N.C. DEPARTMENT OF ENVIRONMENT AND NATURAL RESOURCES  
DIVISION OF ENVIRONMENTAL HEALTH

### Comment Addendum

COUNTY: Harnett  
NAME: Ed Burrito ID: \_\_\_\_\_  
STREET: \_\_\_\_\_  
CITY: Sm. Lake DATE: 7-25  
STATE: \_\_\_\_\_ ZIP CODE: \_\_\_\_\_ TIME: \_\_\_\_\_

EL BURRITO MEXICAN RESTAURANT
 6743-6755 OVERHILLS ROAD
 SPRING LAKE, NC
FLOOR PLAN AND EQUIPMENT SCHEDULE

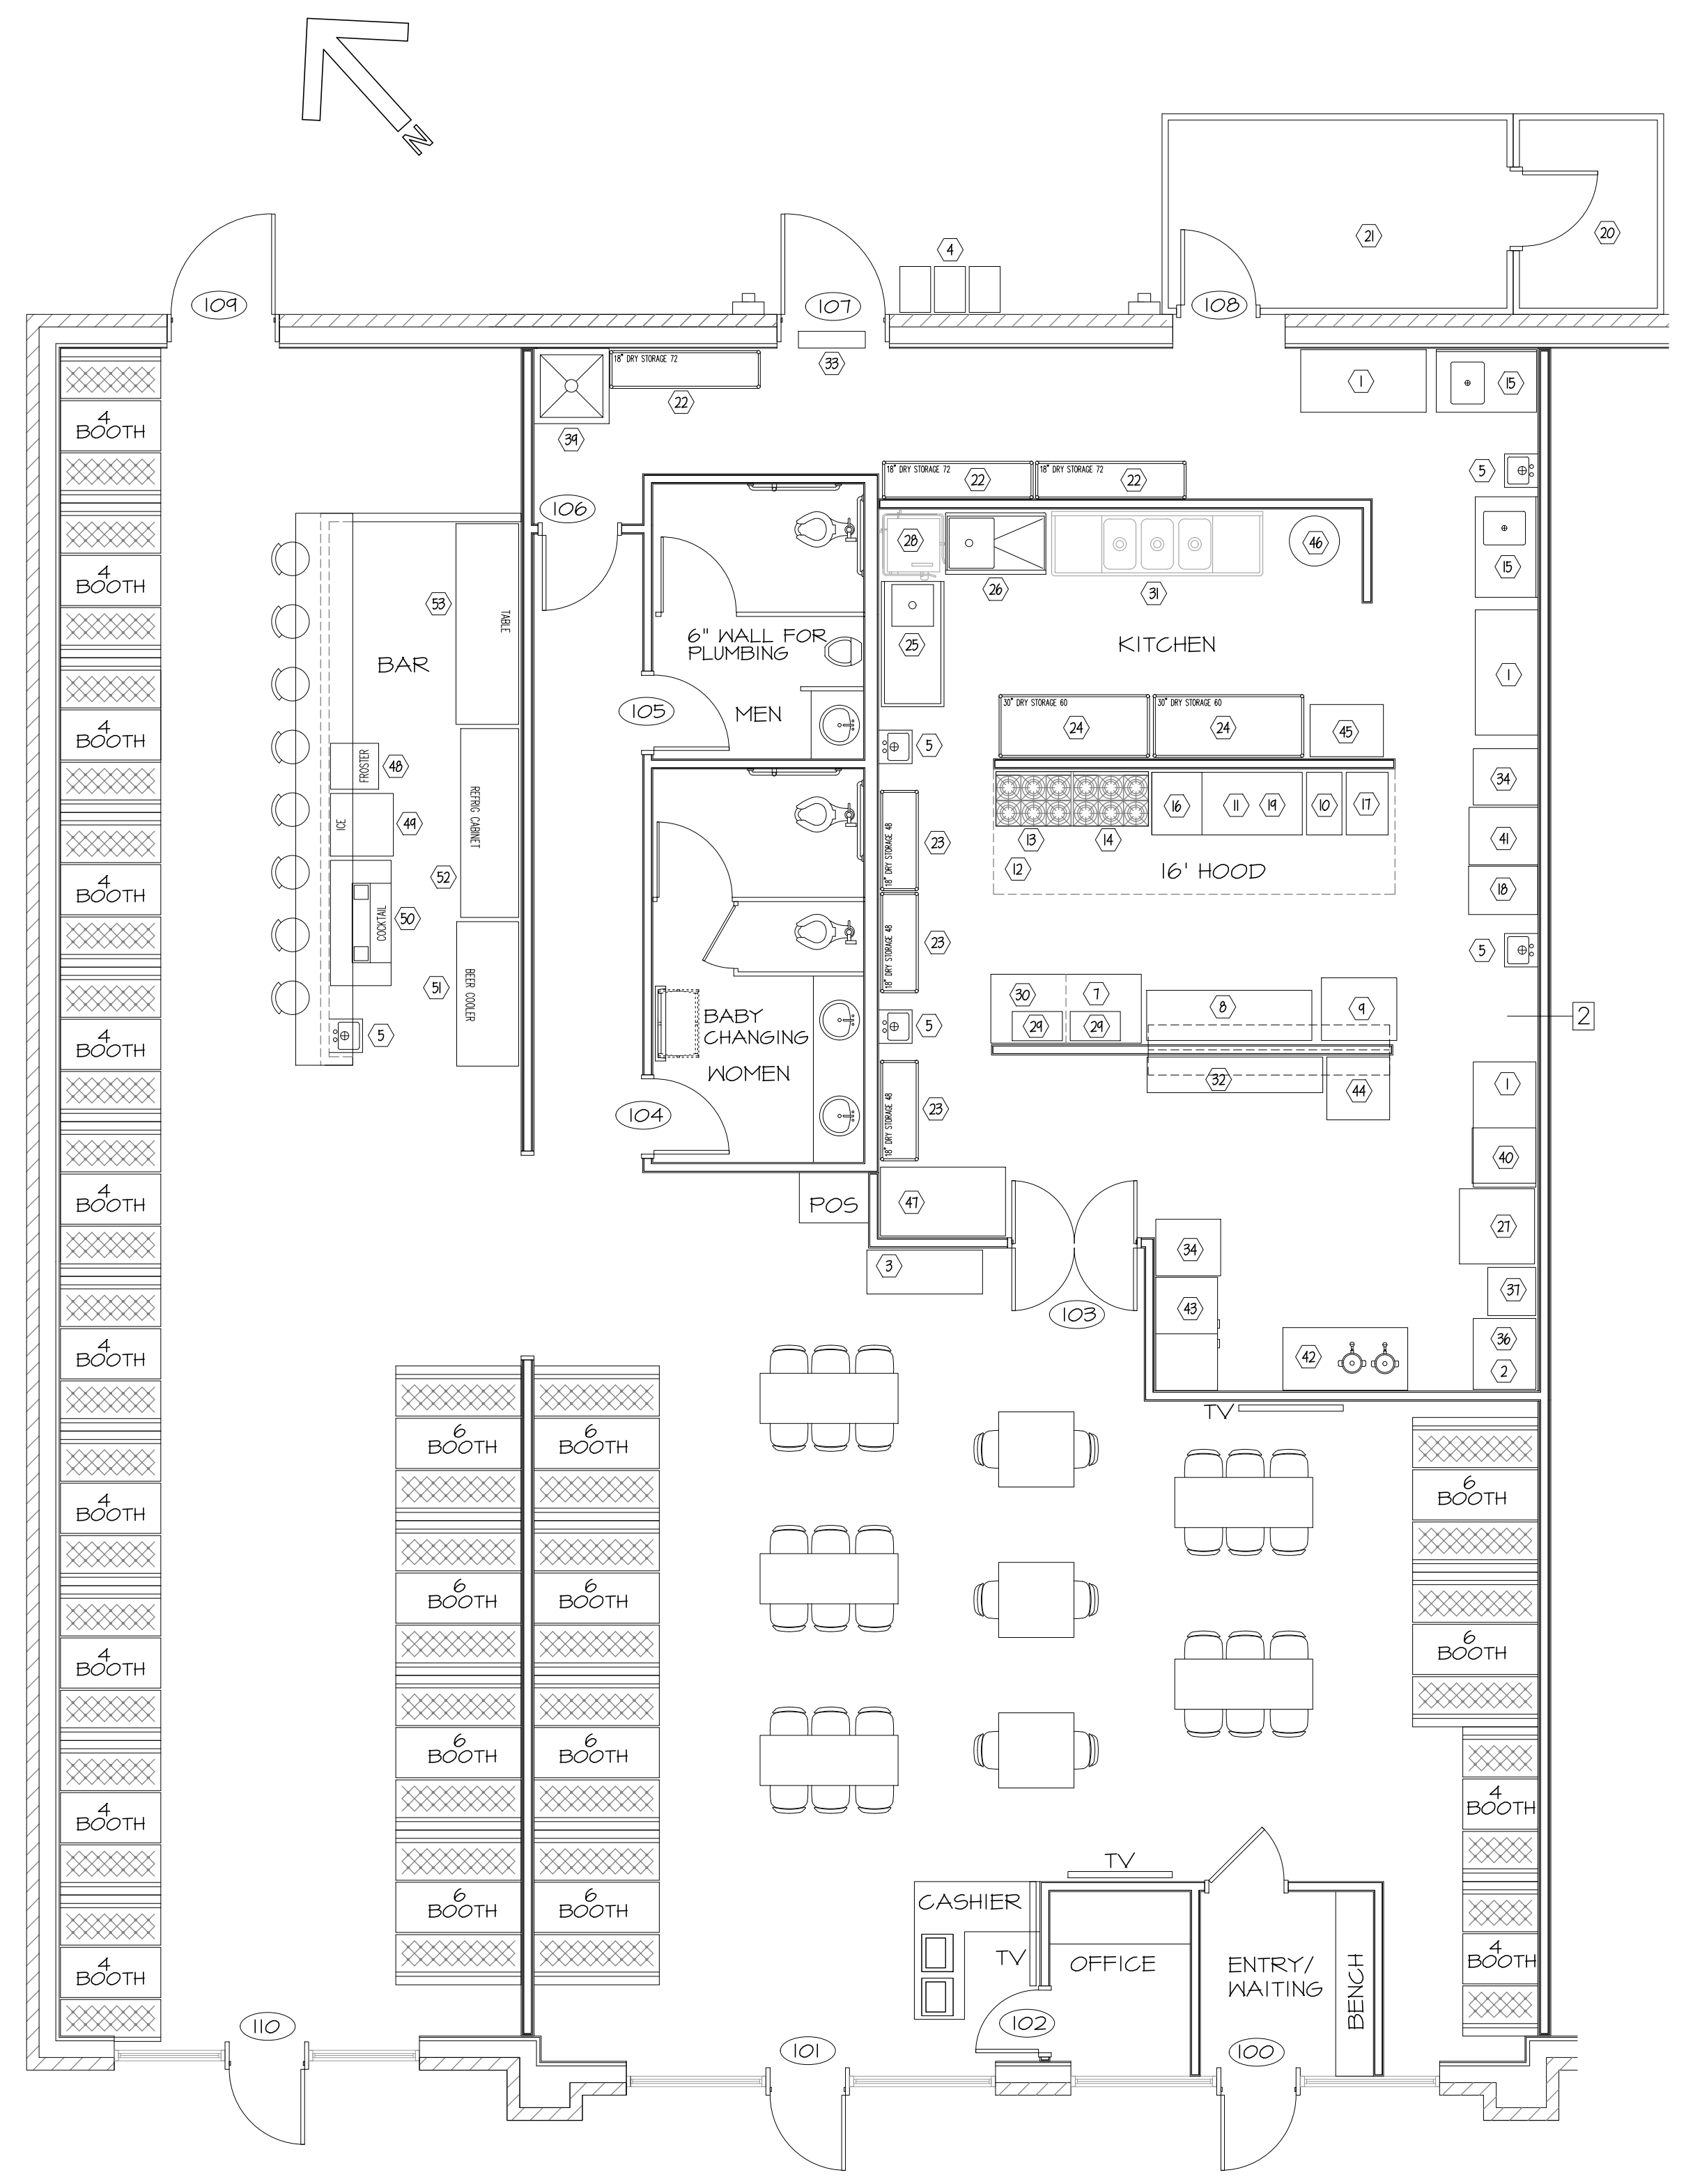
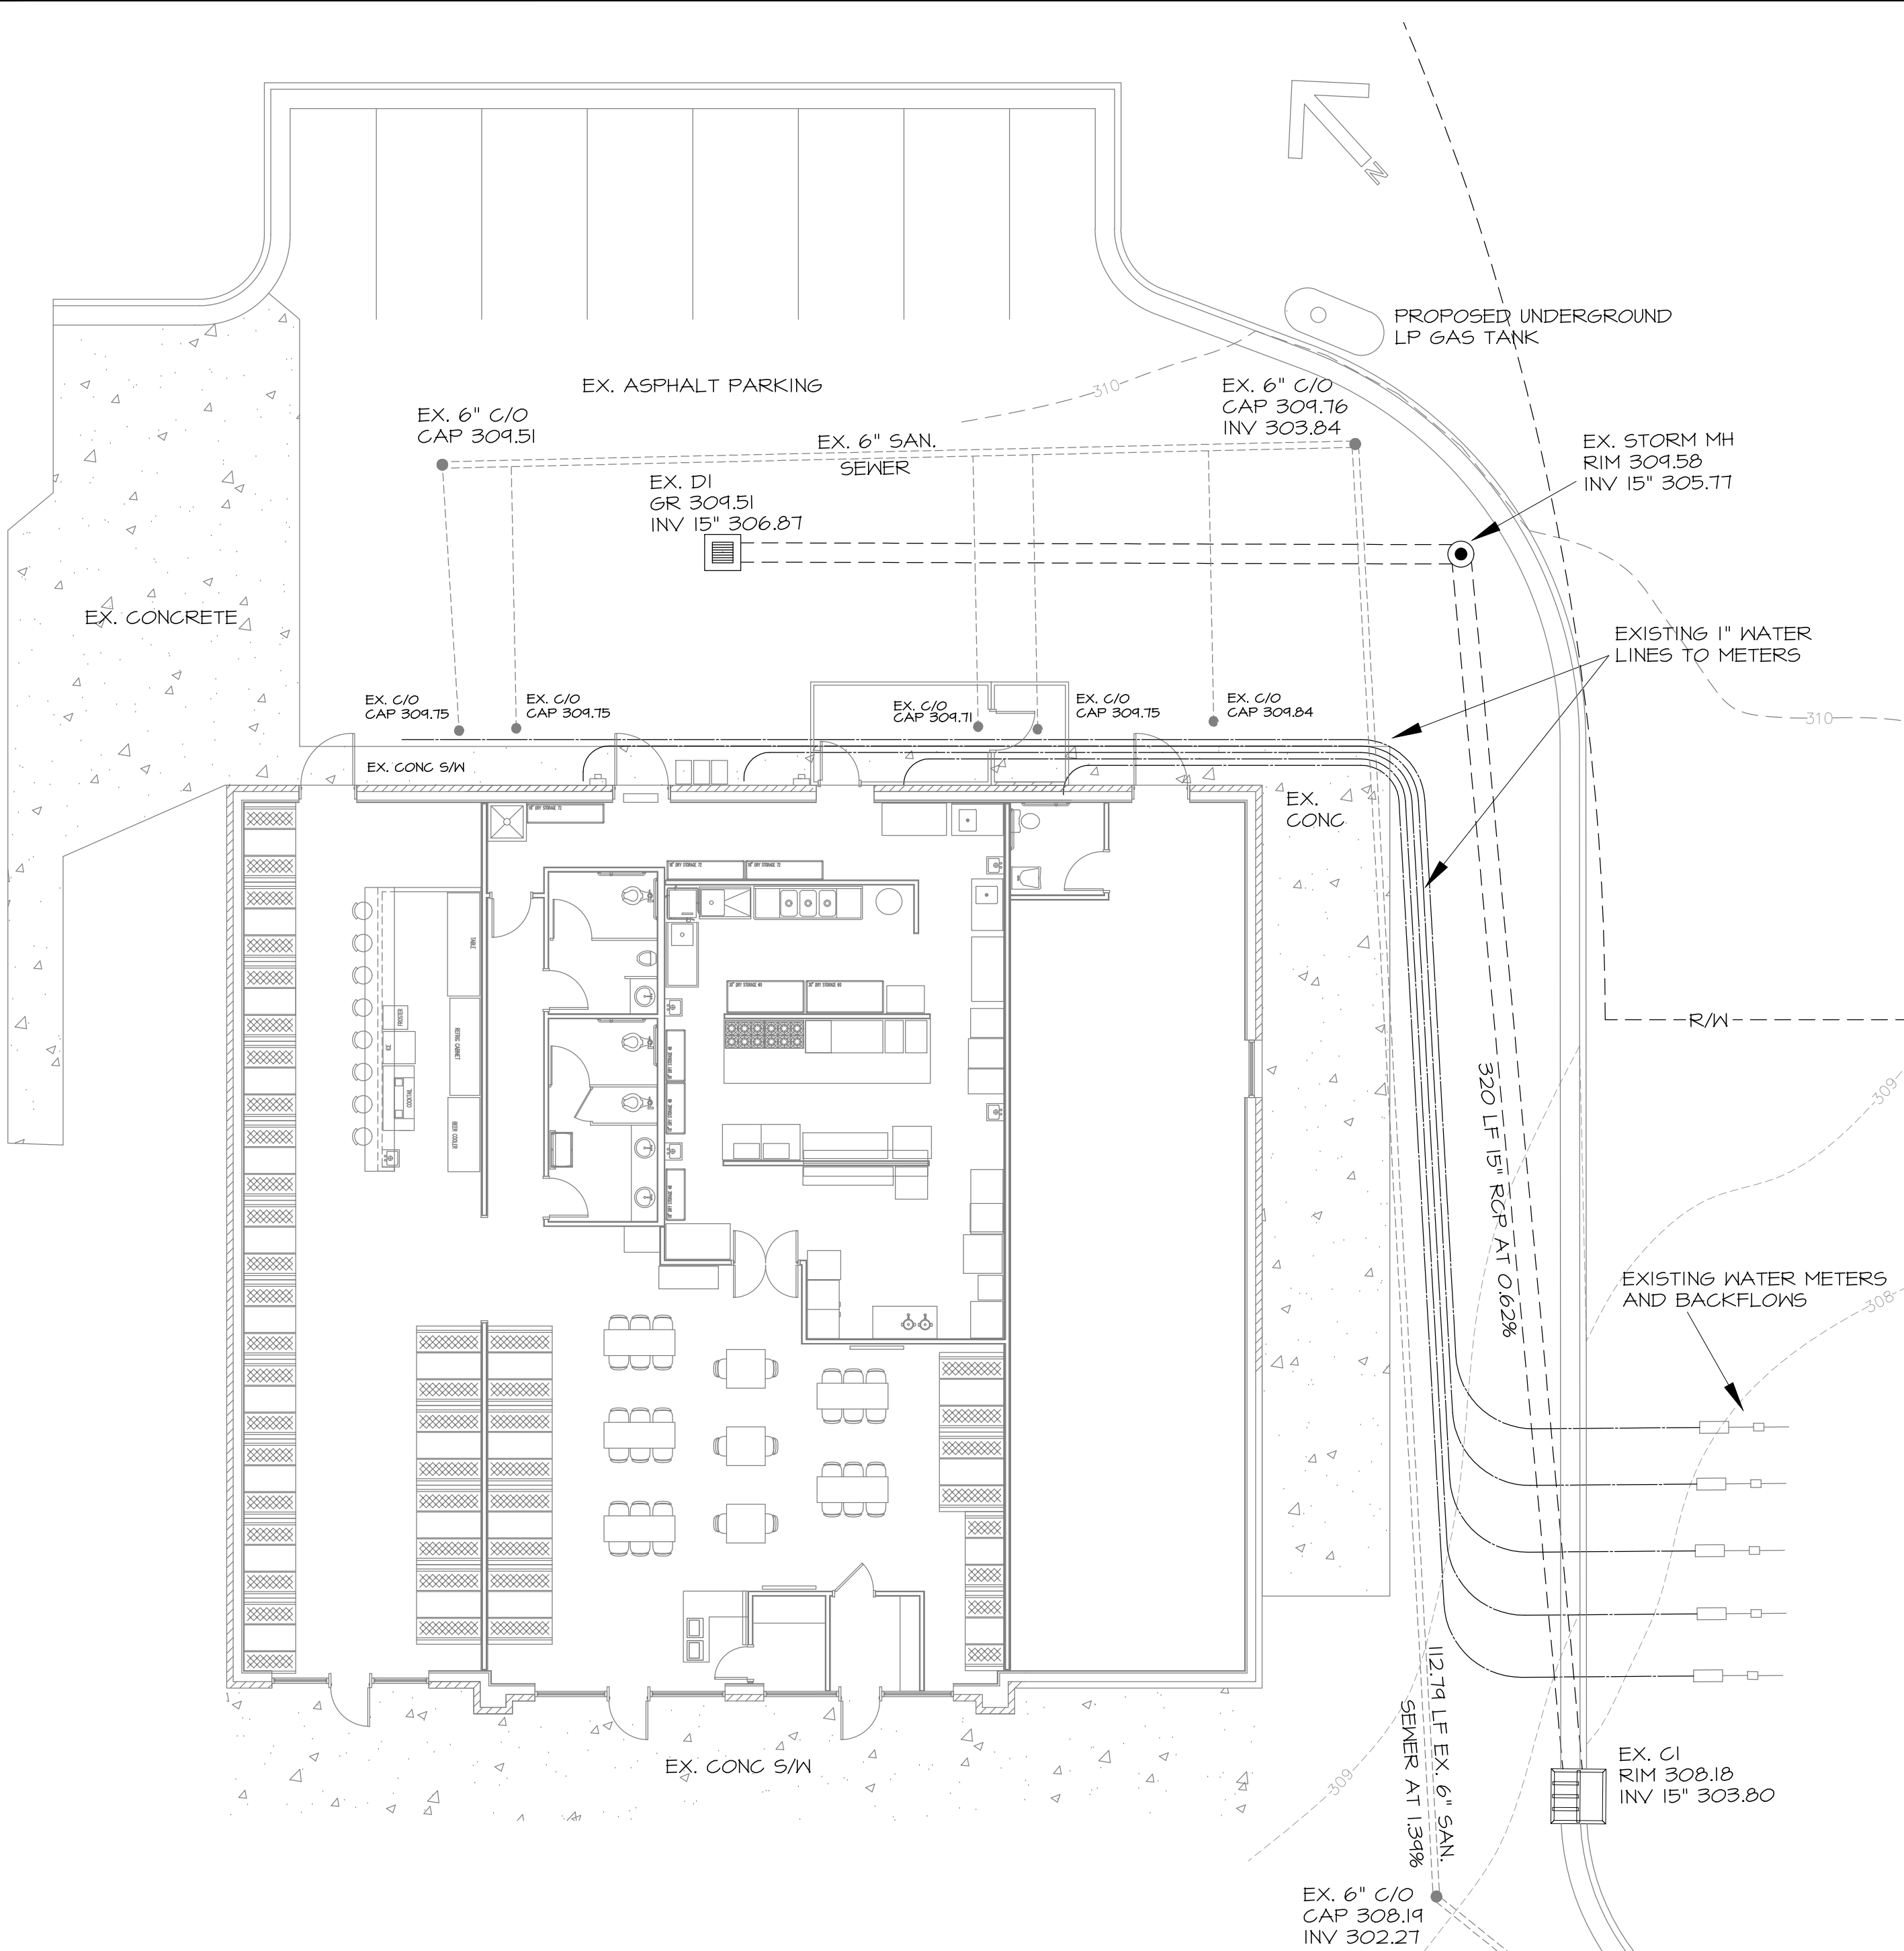
(plan may 2004)  
\*changes noted on plan  
- provide water heater space  
- fix holes in FRP  
- Rear to cooler: boxed in covered smooth cleanable daylight showing exposed brick not smooth + cleanable  
- designated area for personal storage  
- replace acoustic tiles in bathrooms with cleanable coated ceiling tiles  
- paint or otherwise seal raw wood under counters in restrooms so non-absorbent & easily cleanable.  
\* Call Donna Johnson to request final inspection  
(910) 443-7535
